Side two storey extension, front dormer, front porch and new detached garage
2 Elm Avenue East Preston

Thank you for your internet representation made on 12th October 2012 which has been recorded as **an objection** with the comments as follows:

I am commenting on this application on behalf of the East Preston and Kingston Preservation Society. ☐

PROPOSED NEW GARAGE
2 ELM AVENUE
EAST PRESTON

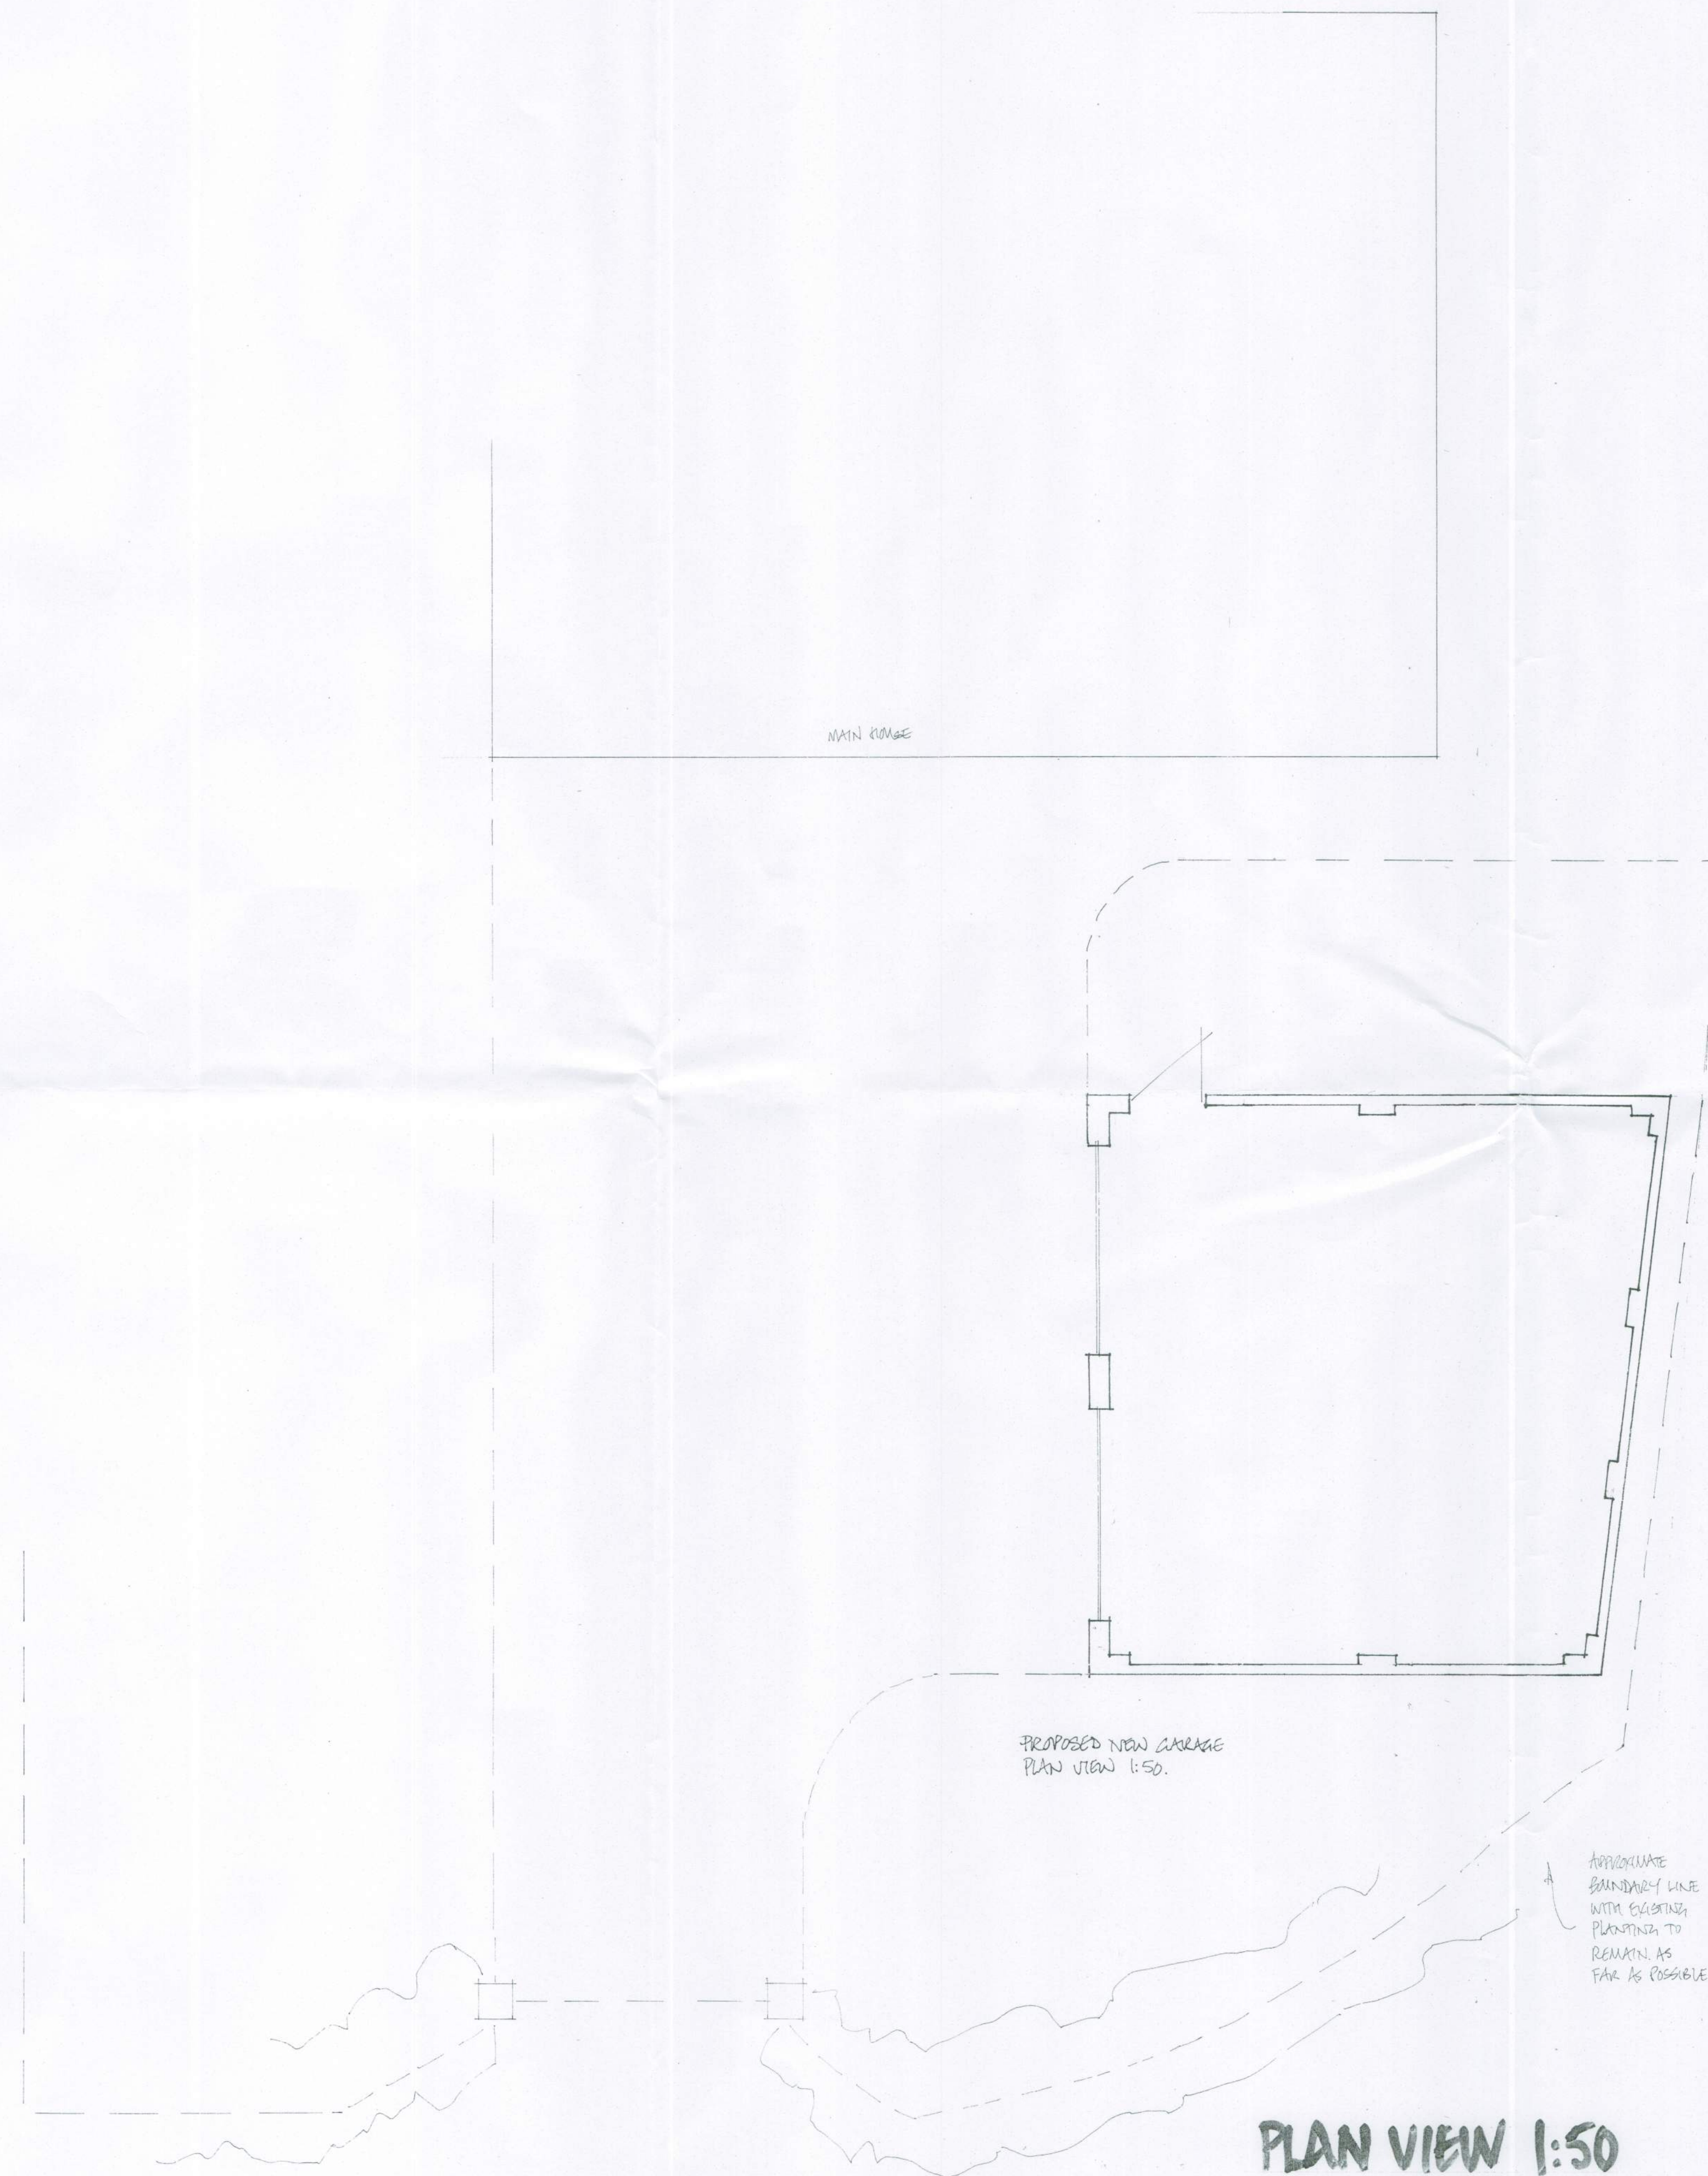
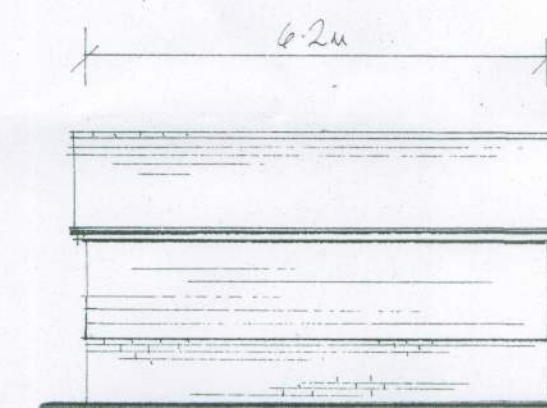
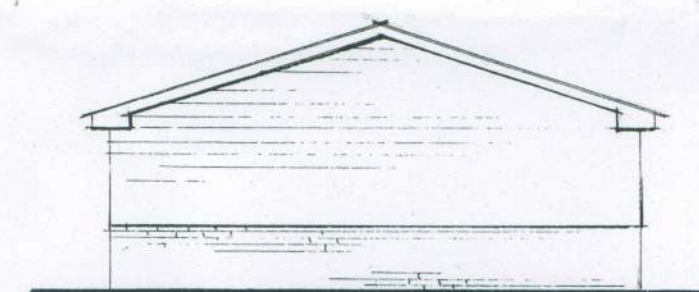
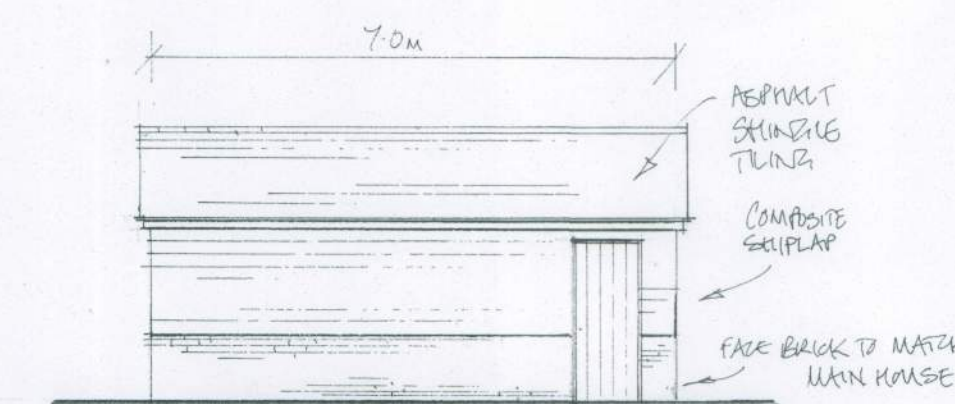
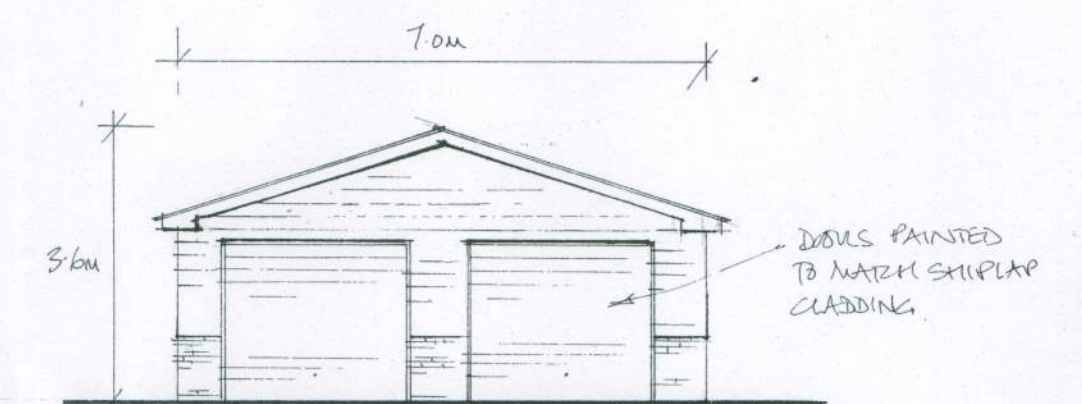
1. The position of the new garage, close to the road and ahead of any existing buildings in the road, would conflict with policy GEN7, because it does not respond positively to the characteristics of the site; with policy DEV19, because it affects the spatial character and pattern of the street; and with the guidance concerning the Elm Avenue Area of Special Character, which emphasises the importance of the regular building line in the area. ☐

2. The use of shiplack cladding on the new garage and the facade of the house. This material is not used on any other building in the road, and its introduction would be contrary to policy DEV19, because the extension would not be visually integrated with the existing building in materials, while the use of this material on the extension and garage would compromise the pattern of the street; and the use of this material would also be contrary to the guidelines of the East Preston Village Design Statement, which emphasises that materials in new buildings should harmonise in both colour and texture with those in existing buildings in a road. ☐

For these reasons, this application should be refused. It might be acceptable if the garage was omitted, and if the materials used on the house were brick and rendering to match the materials in adjoining houses. ☐
